Letter No. A1/14857/97

Sub: CMDA - Planning Permission - Construc-
tion of Residential building at S.No.
88/2B of Perumal Nagar 3rd Cross Street,
Ullagaram village - Scrutiny Fee to be
remitted - Regarding.

SITE PLAN
SCALE: 1" TO 10'0"

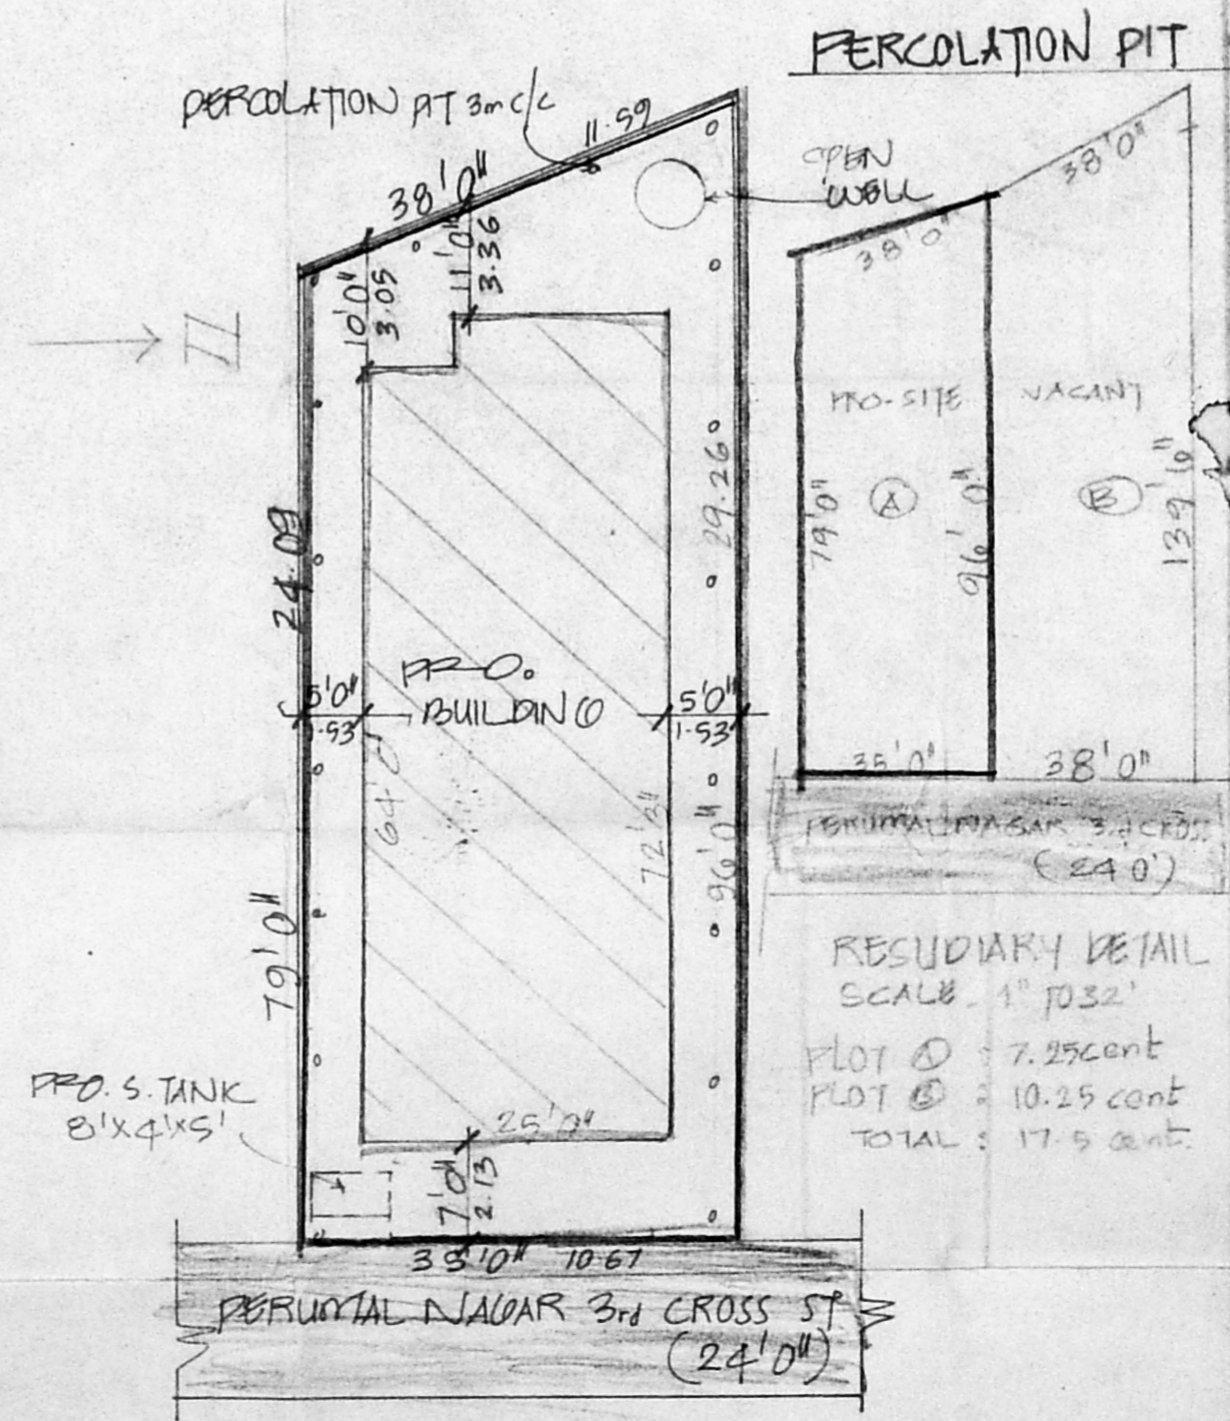
4. You are request to furnish the residuary plot details, and proposed plan as per the site condition.
